PLANNING CONSULTATION RESPONSE

Application No	2025/1092
Proposal	Demolition of TPT bridge over Grange Lane at Stairfoot roundabout
Address	Grange Lane, Stairfoot
Date of Consultation Reply	21 August 2026
Consultee	PROW

Proposed Cross Sections

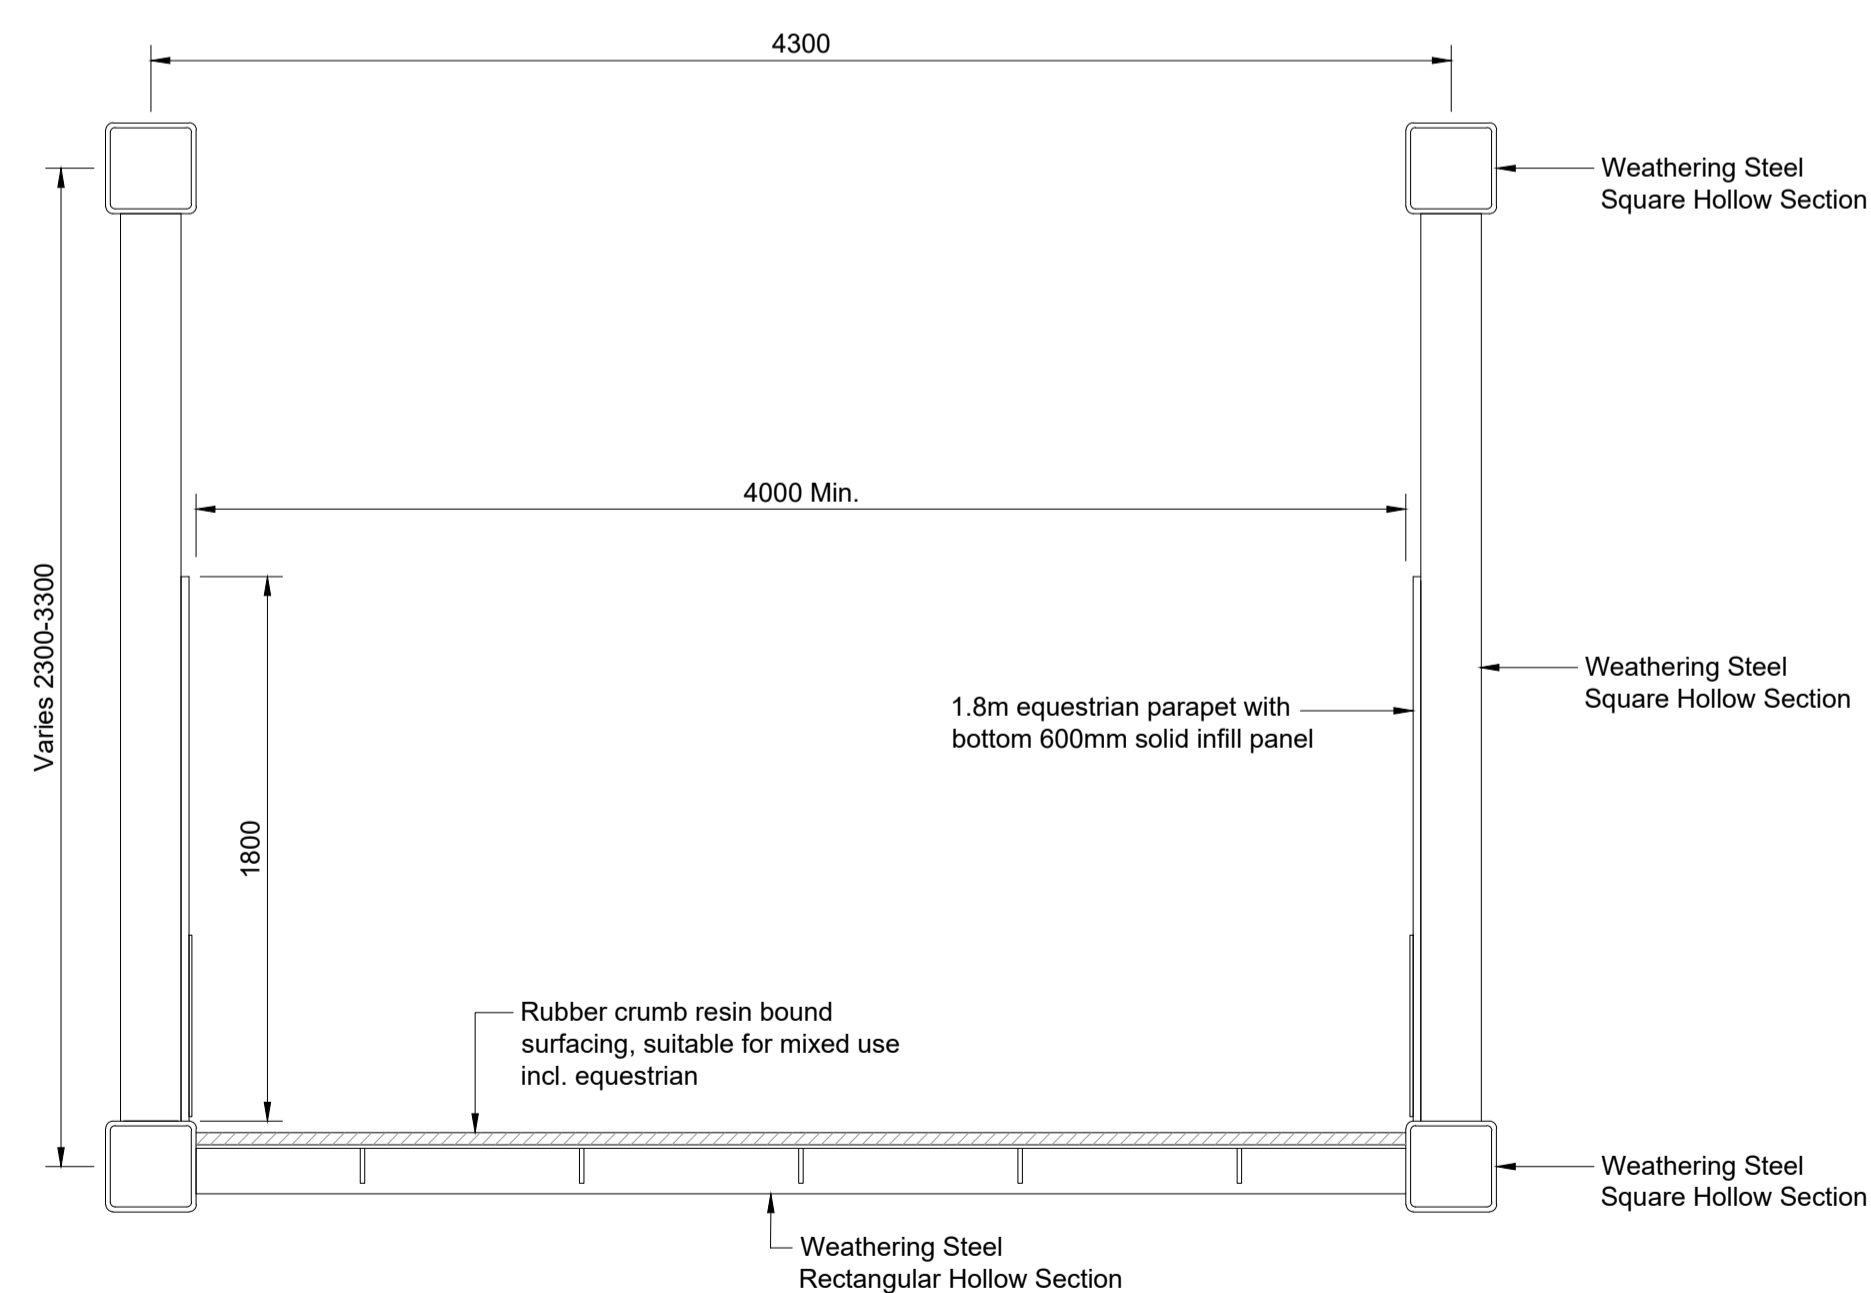
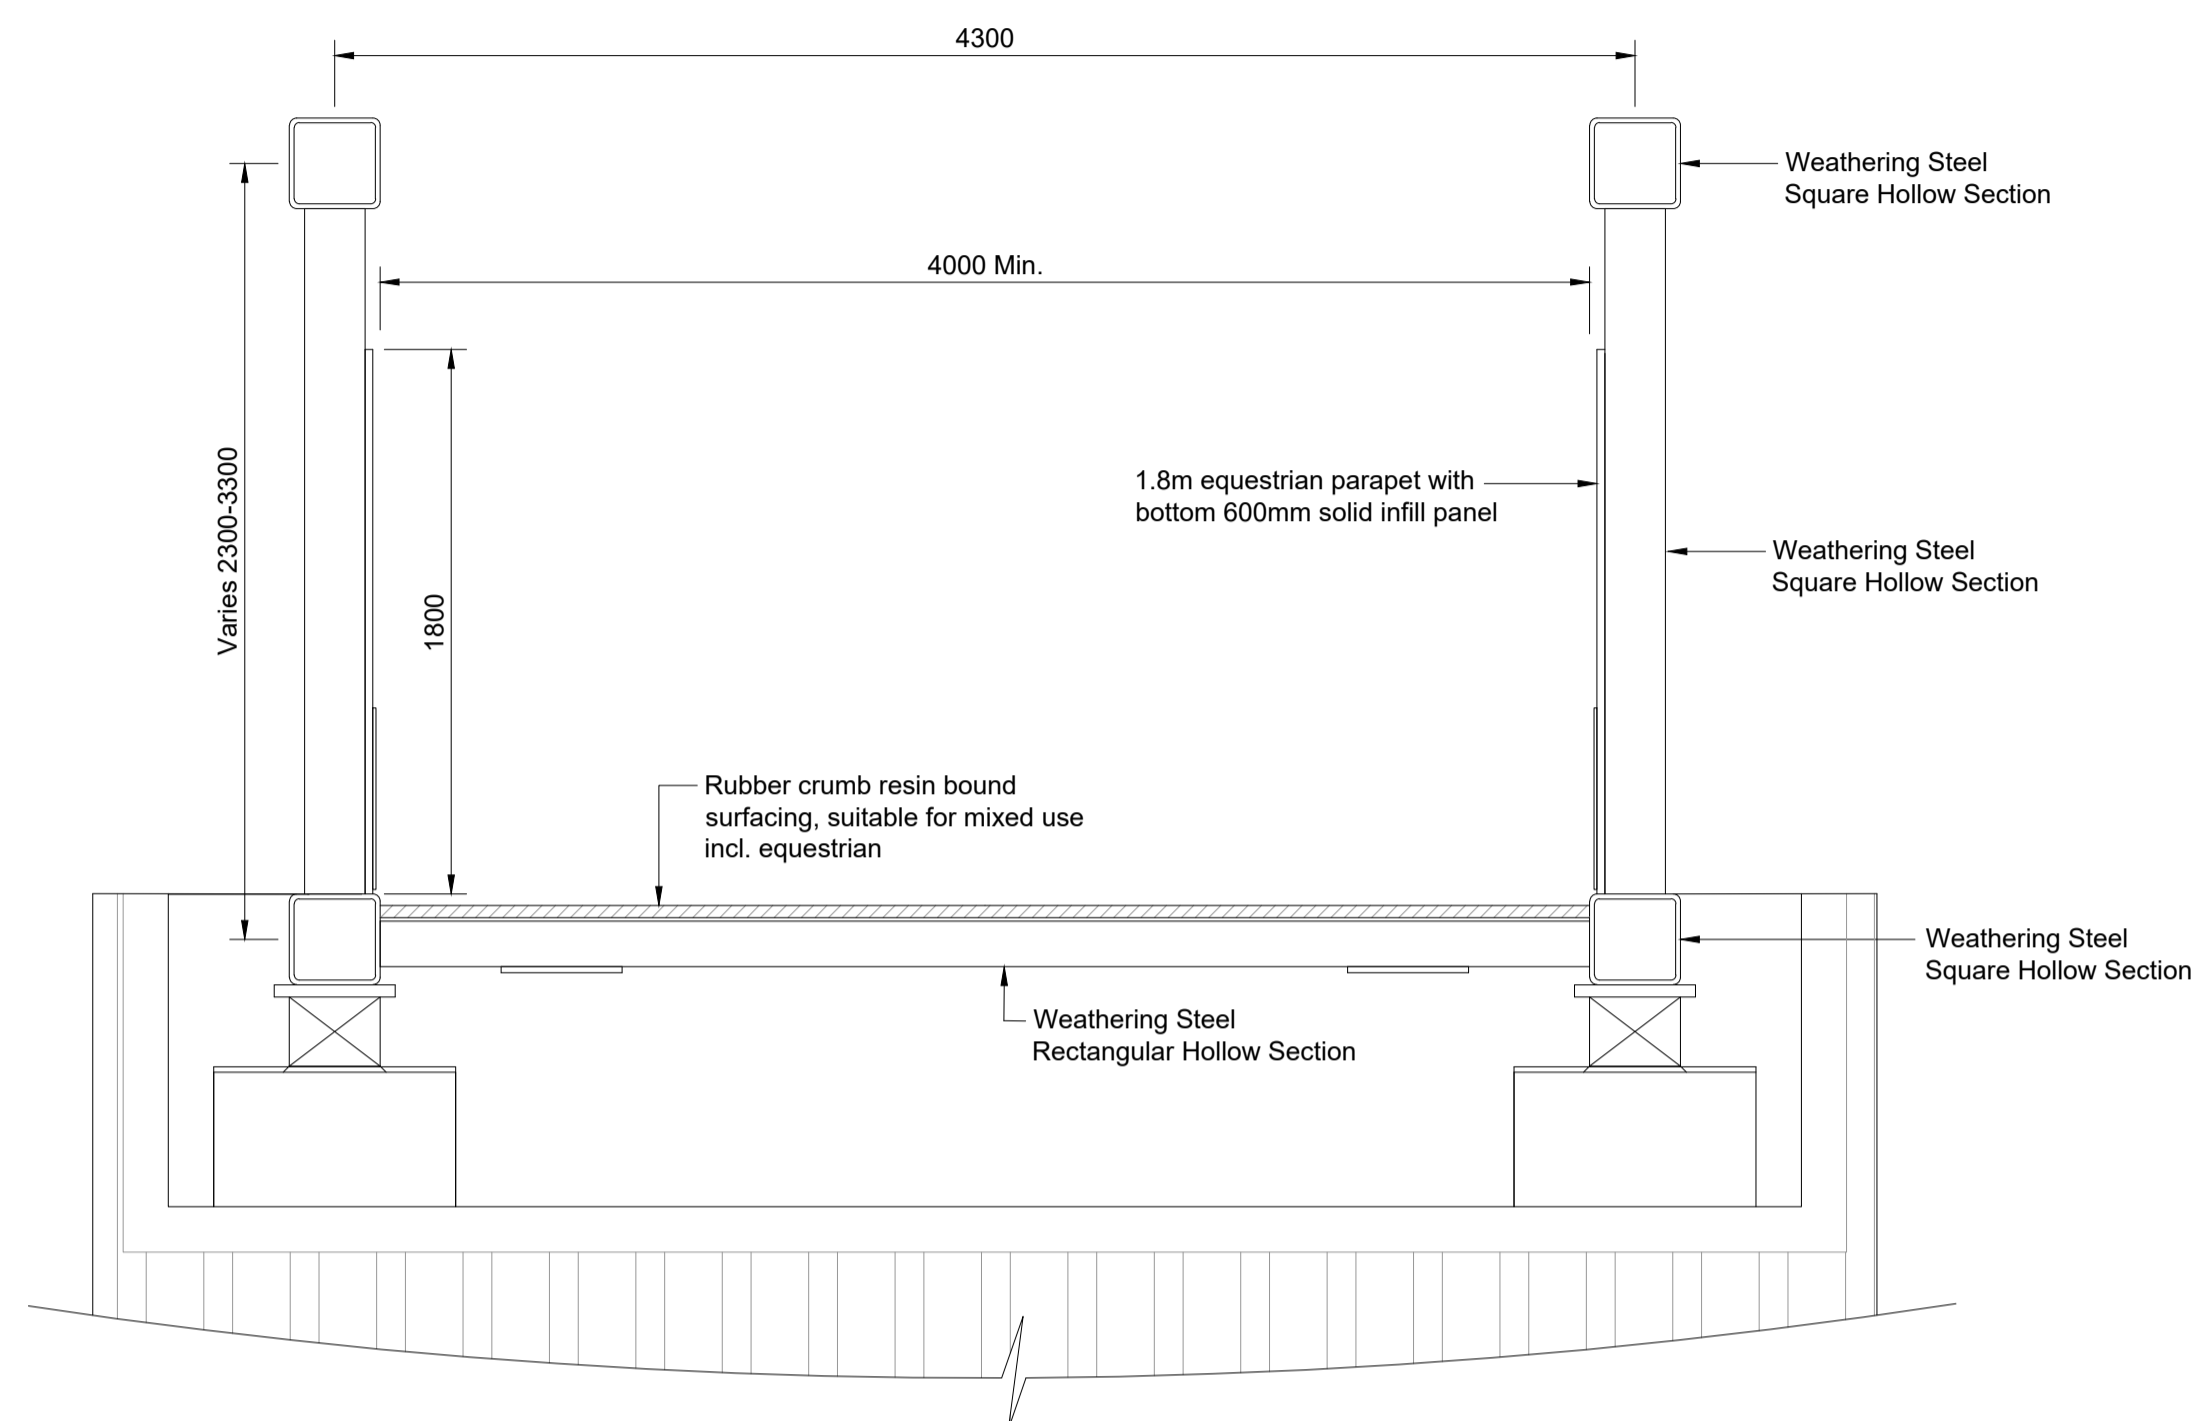
- Access **MUST** be maintained for all users on the north/south section of the Trail to the east of the closure including crossing at grade over the old Doncaster Road
 - The footpath ramp down to Doncaster Road by the substation should be made available to all bridleyway users along with an AT grade crossing of Grange Lane throughout the works to enable users to rejoin the open section of the TPT
 - The contractor will need to apply and pay for a temporary closure of this section of the TPT via the PROW team. We need at least 6 weeks notice prior to the start date.
 - This is a bridleyway so the bridge design and installation **MUST** comply with noise reduction, surfacing for non slip and solid parapet to 1m standards set out by British Horse Society

and Traffic regulations. PROW team to be fully involved in decision making and consultation on final design along with BHS regional rep Mark Corrigan

Drawing Title: **Landscape General Arrangement Planning Application**

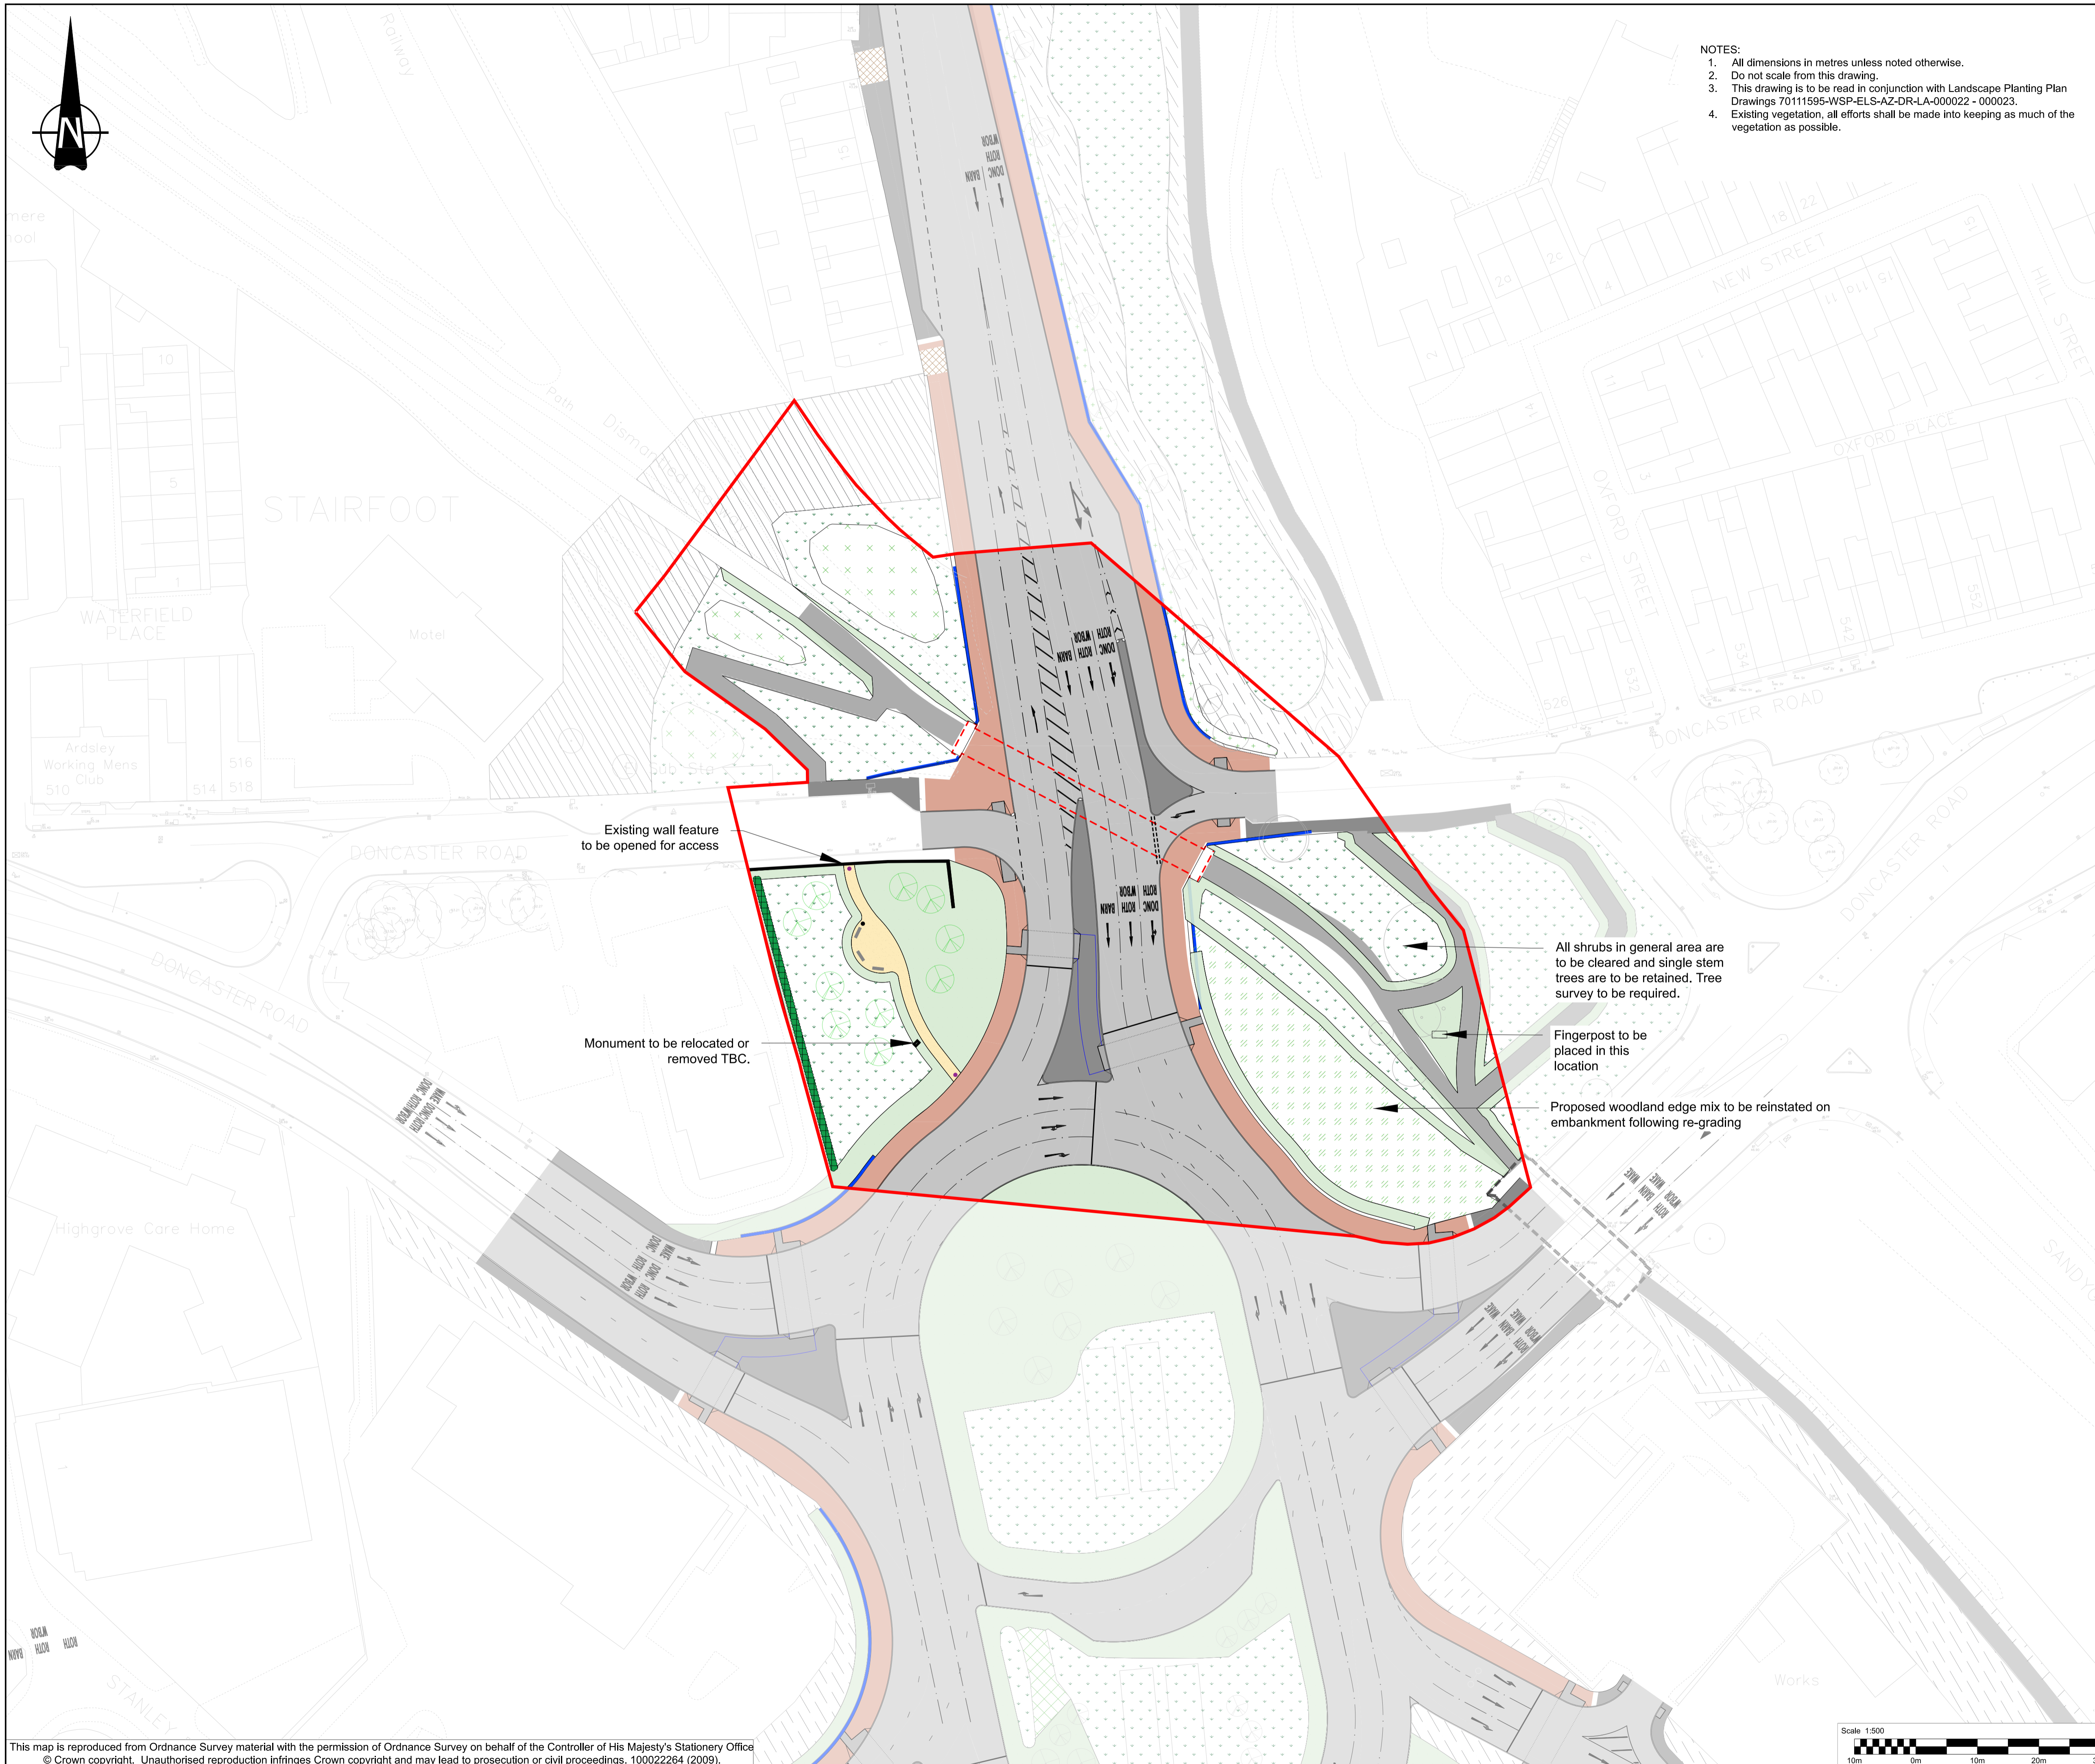
We agree with the landscape reinstatement which has been drawn up by Active travel with ourselves.
